Consultation Response from KC, Highways Development Management
2024/93209 65A, Westgate, Almondbury, Huddersfield, HD5 8XF
Alterations to existing ground floor garage and first floor to extend living accommodation (Listed Building within a Conservation Area)
Date Responded: 19/12/2024. Responding Officer: D. Stainsby Responding Ref: K2-20NE/22

TITLE
**PROPOSED FLOOR PLANS
 & ELEVATIONS**

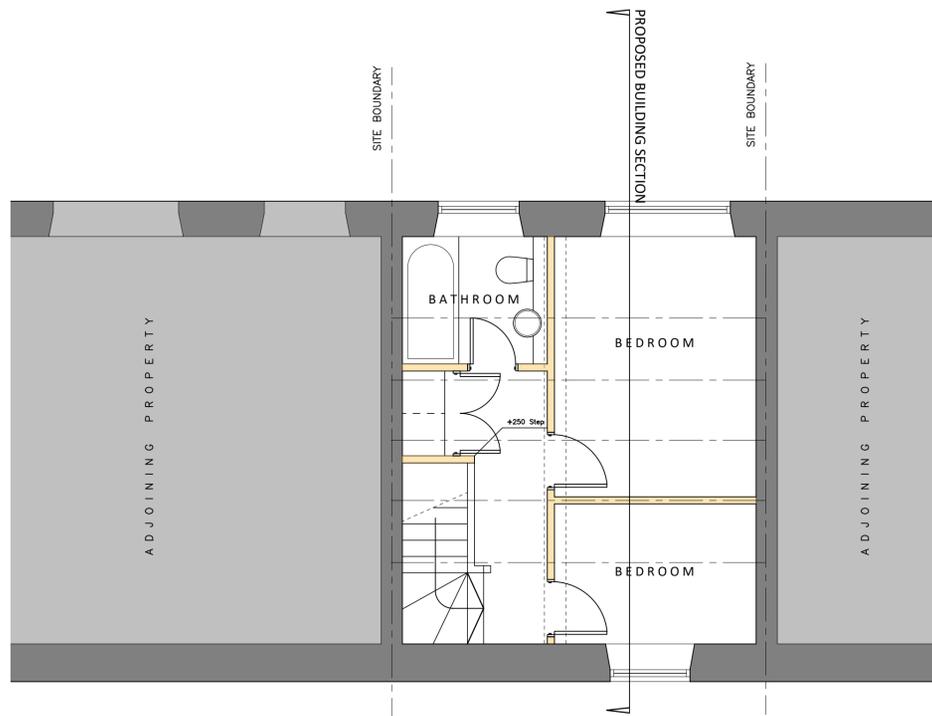
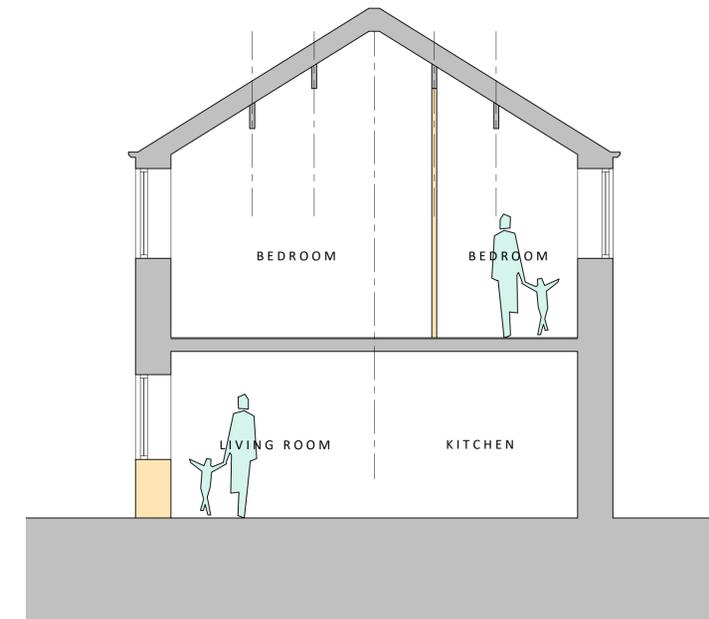
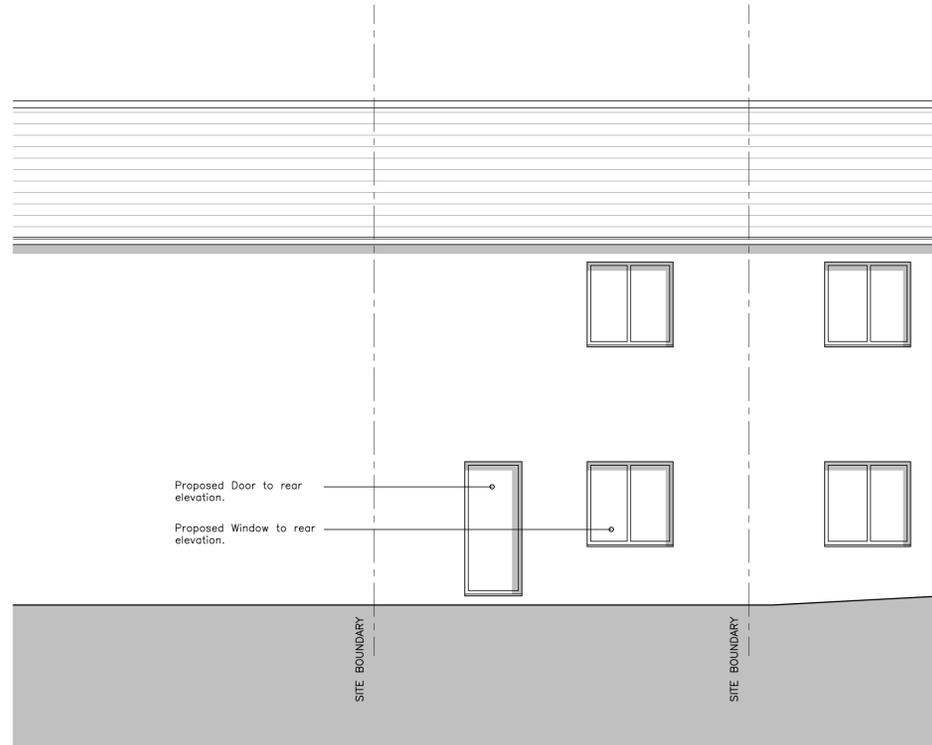
As submitted the proposals are not acceptable to Highways.

A revised drawing showing two off street parking spaces is required.

Currently the property has 2 parking spaces. One space in the garage and one space on the driveway. which meets the guidelines

This proposal will reduce the available off-street parking to one space on the driveway.

The Kirklees Highway Design Guide recommends that a 2 to 3 bedroom dwelling requires a minimum of two off street car parking space per dwelling.

As a result, Highways D.M cannot support the application as submitted
